Ribble Valley Borough Council
Church Walk,
Clitheroe,
BB7 2RA

Phone: 0300 123 6780
Email: lhscustomerservice@lancashire.gov.uk
Your ref:
Our ref: LHS/CS/3/2015/0571
Date: 4th August 2015

Proposal:	Extension to existing building to create a cattery and stables, construction of manege, midden and access arrangements
Location:	Four Acres Pendleton Road Wiswell Lancashire BB7 9BZ
Grid Ref:	374791 - 437678

Proposed Site Plan

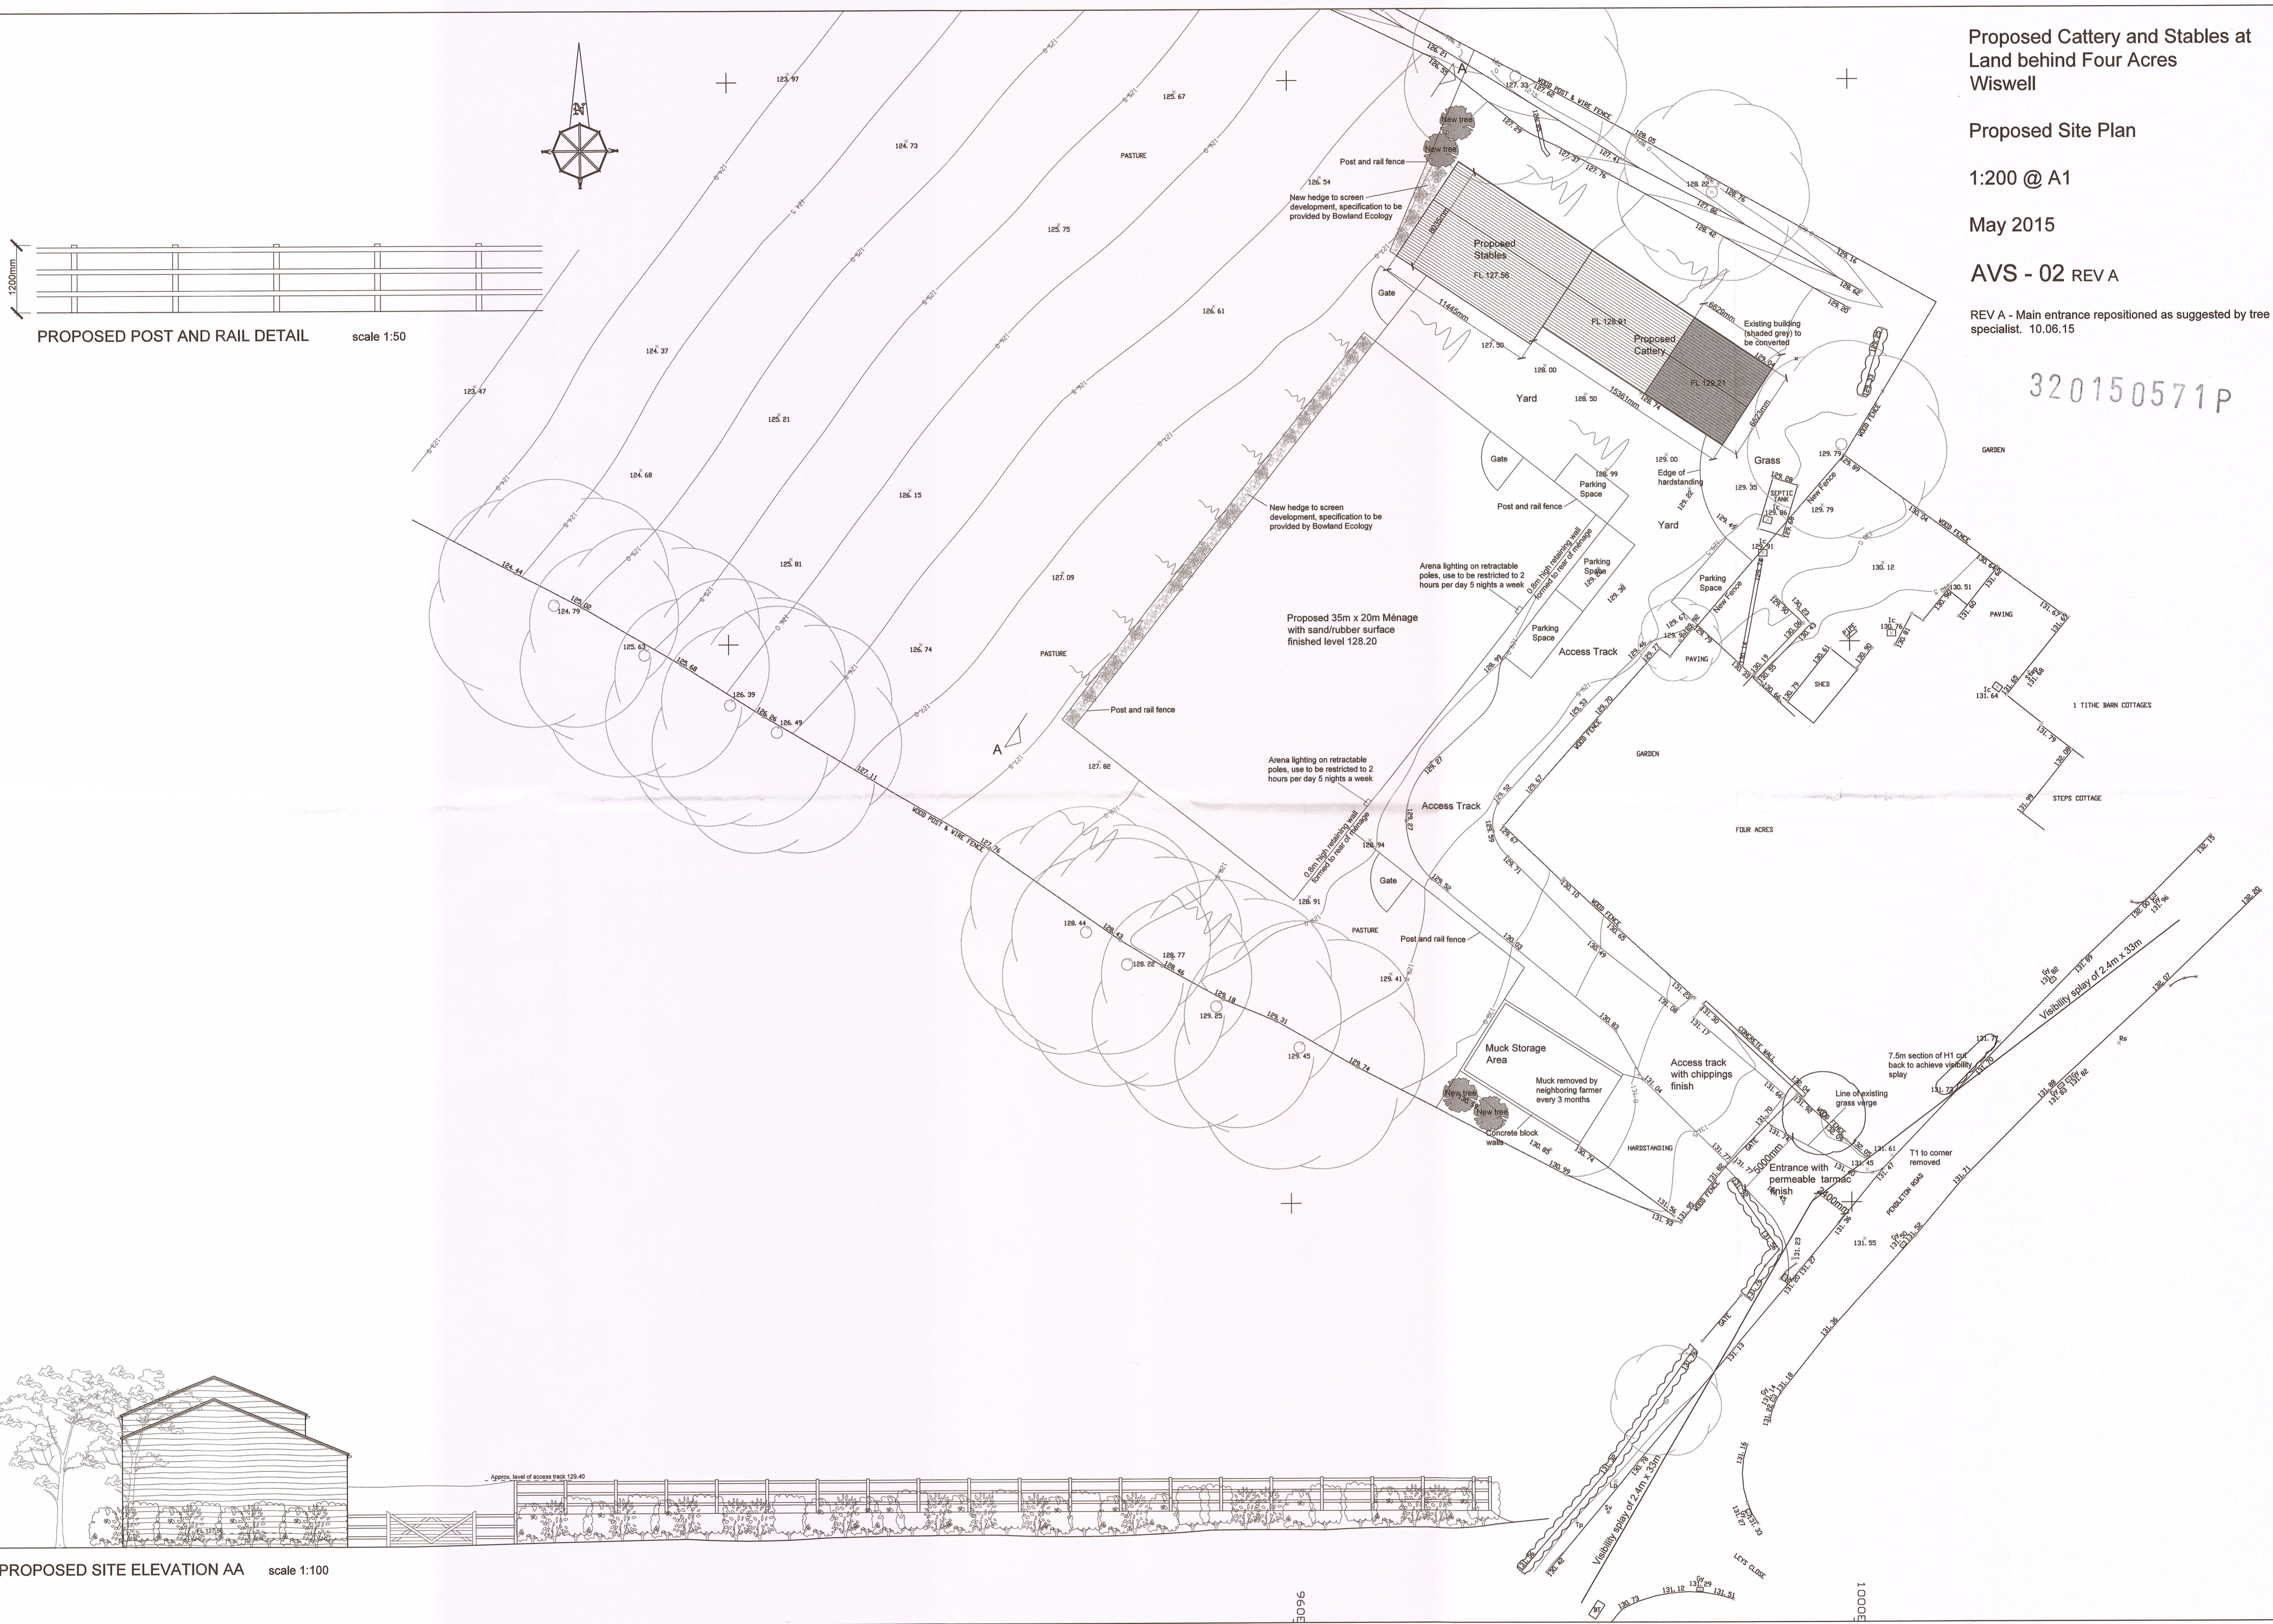
The sight lines of 2.4 x 33m to be provided in both directions from the centre of the site access onto Pendleton Road. The site line requirement is based on table 7.1 from Manual for Streets and an estimated wet road 85th percentile speed of 25mph.

The applicant should provide accurate details of the required sight line requirement, before determining the application, ensuring the entire sight line requirement is fully over land within the applicants control and/or over the adopted highway and to fully show all works which would be required to provide the sight lines. The sight line splays will require walls, fences, trees, hedges, shrubs, ground growth, structures etc. to have a maximum height of 1.0m above the height at the centre line of the adjacent carriageway.

The applicant has shown sight lines to the centre of the road and they should be to the near side carriageway edge, on these narrow country roads it should be expected that vehicles are on the wrong side of the road to pass pedestrians, cyclist, horse riders etc.

From observations on site and the information provided on the applicant's site location plan the sight line requirement to the north would be fully achievable over the applicants land and the existing adopted highway, but this will require cutting back vegetation and

the reduction in height of the garden wall, to below 1m high. The sight lines to the south would be partly over third party land and these sight lines could not be provided by the applicant.

1. No part of the development shall be commenced the visibility splays measuring 2.4 metres by 33 metres in both directions to be provided, measured along the centre line of the proposed new road from the continuation of the nearer edge of the existing carriageway of Pendleton Road, to the satisfaction of the Local Planning Authority. The land within these splays shall be maintained thereafter, free from obstructions such as walls, fences, trees, hedges, shrubs, ground growth or other structures within the splays in excess of 1.0 metre in height above the height at the centre line of the adjacent carriageway.
Reason: To ensure adequate visibility at the street junction or site access in the interest of highway safety in accordance with Quality of Development Policy and Transport Policy in the Local Plan.

2. The car parking and manoeuvring scheme to be marked out in accordance with the approved plan, before the use of the premises hereby permitted becomes operative and permanently maintained thereafter. Reason: To allow for the effective use of the parking areas.
